SADDLEHORN RANCH FILING NO.3

JOB NO. 25142.05
APRIL 24, 2023
SHEET 1 OF 5

PCD FILE: SF-23-004

V2_Final Plat Drawings.pdf Markup Summary

JOB NO. 25142.05
APRIL 24, 2023
SHEET 4 OF 5

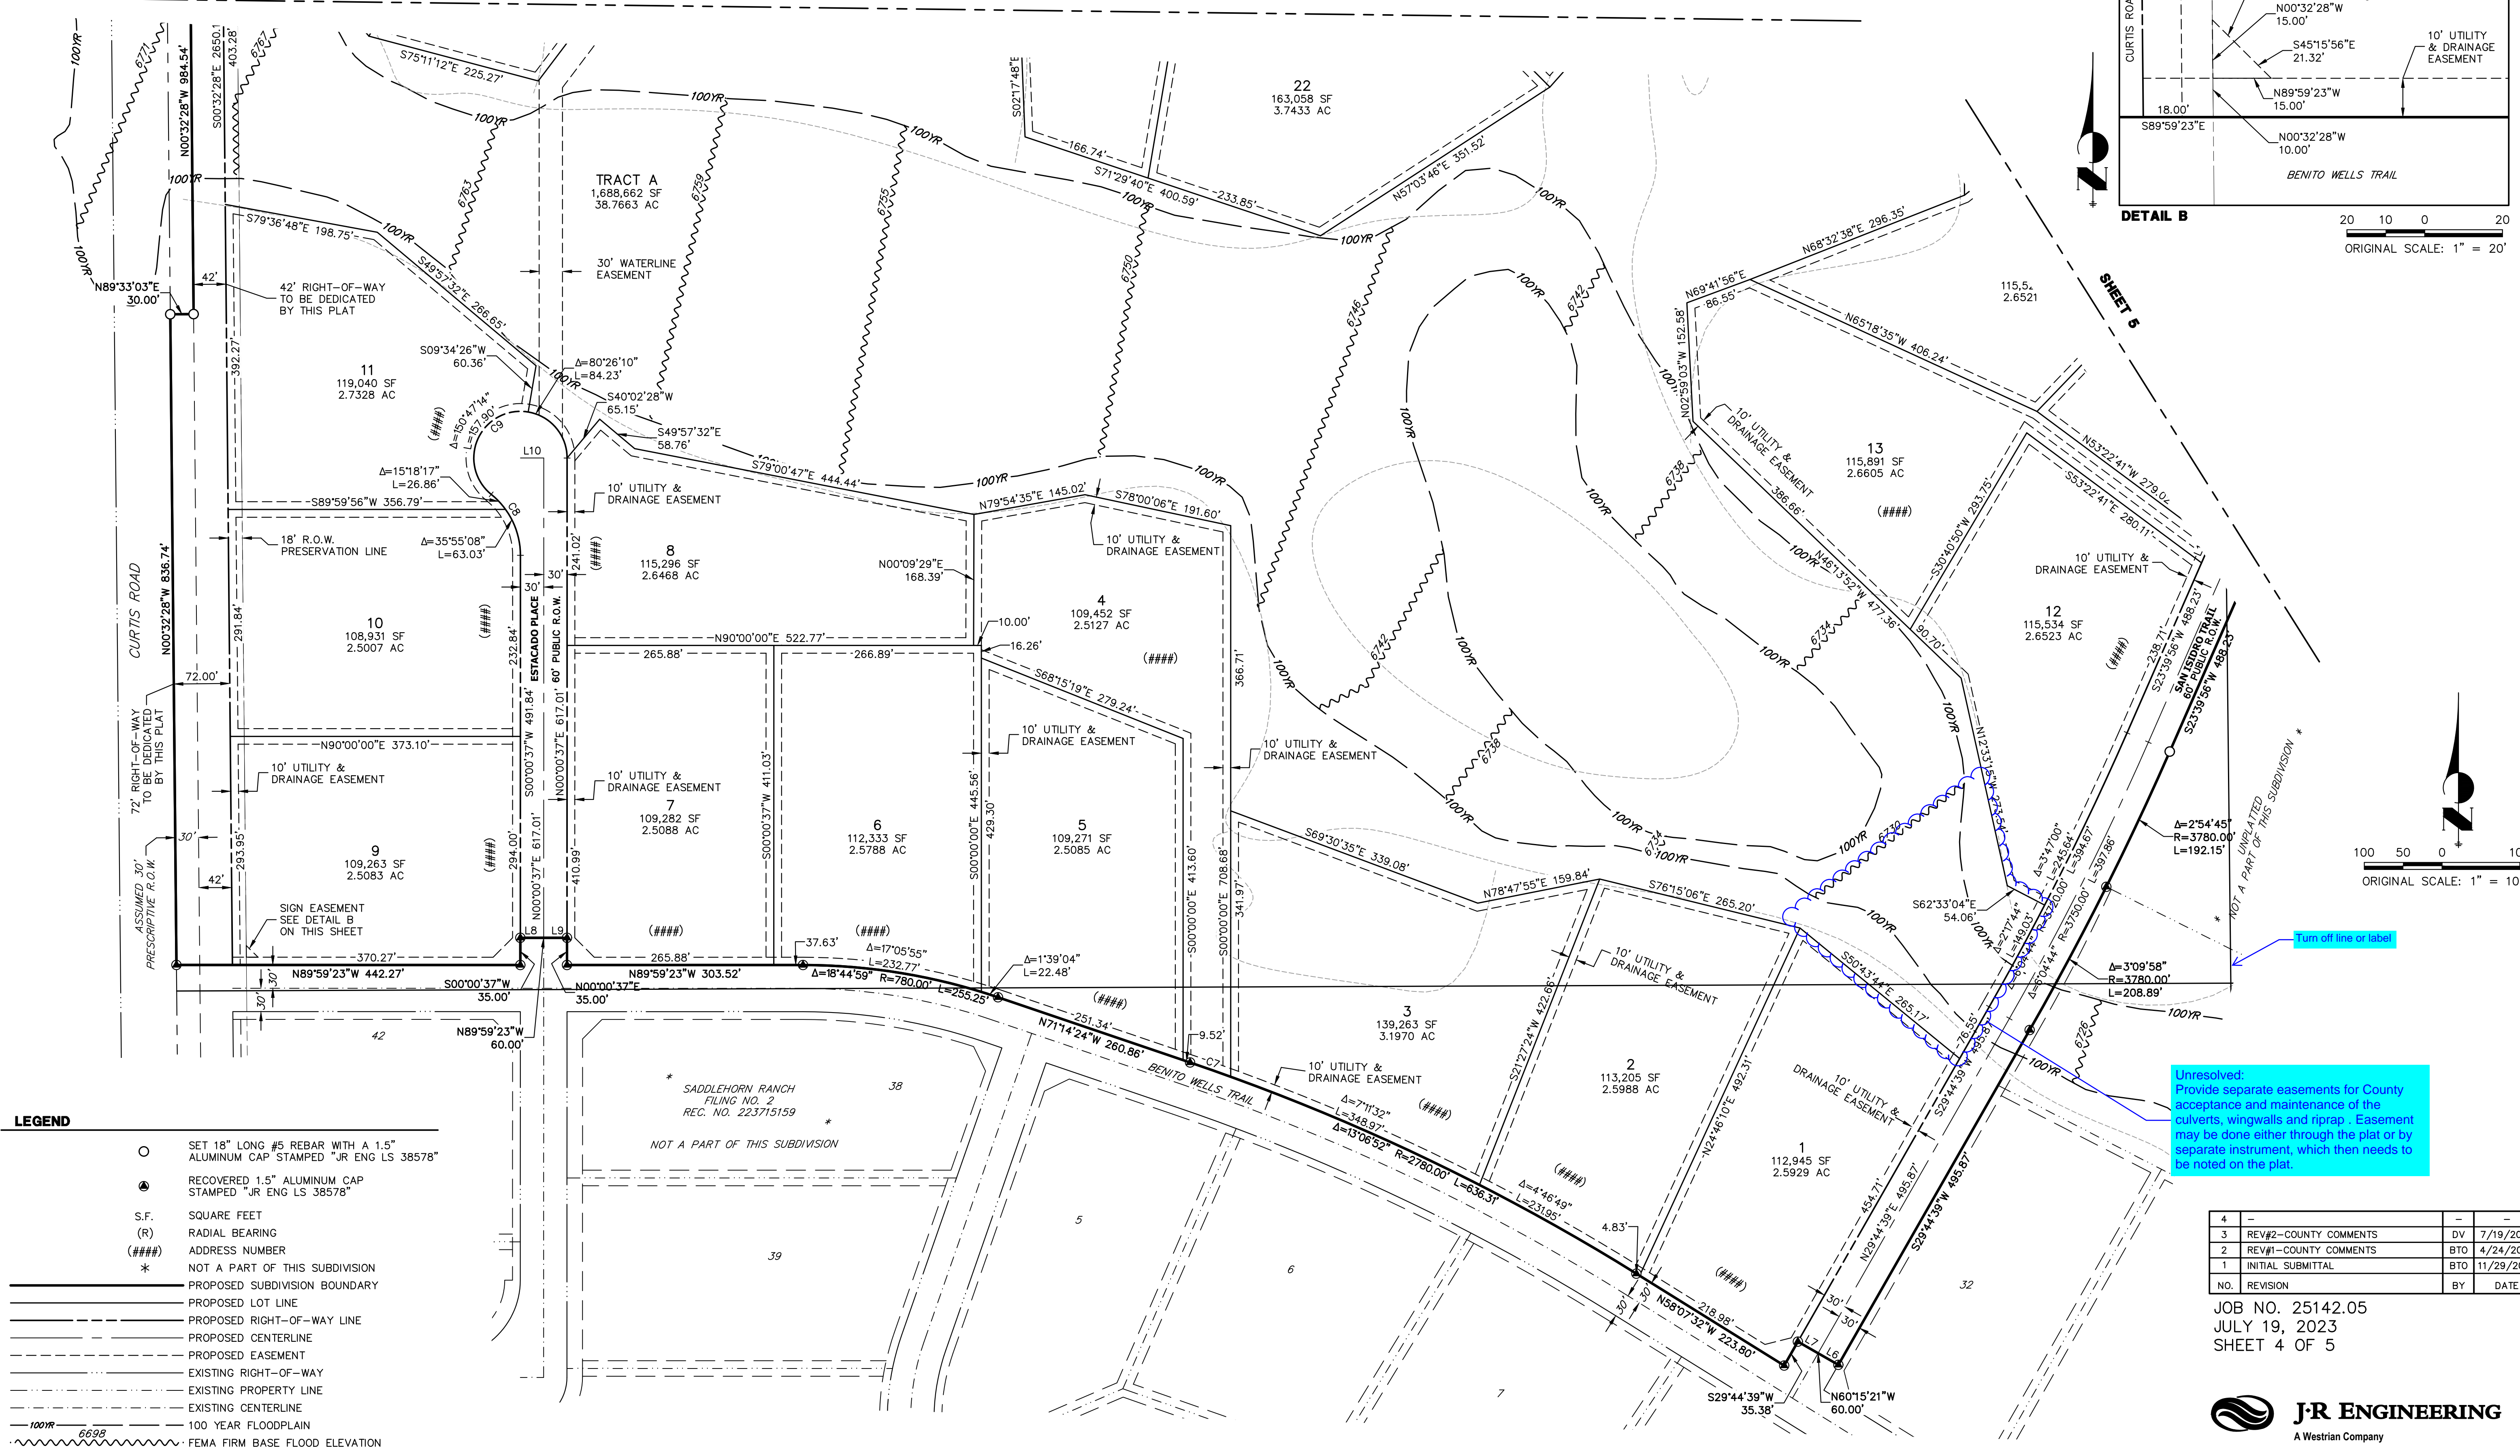
Unresolved:
Provide separate easements for
County acceptance and maintenance
of the culverts, wingwalls and riprap
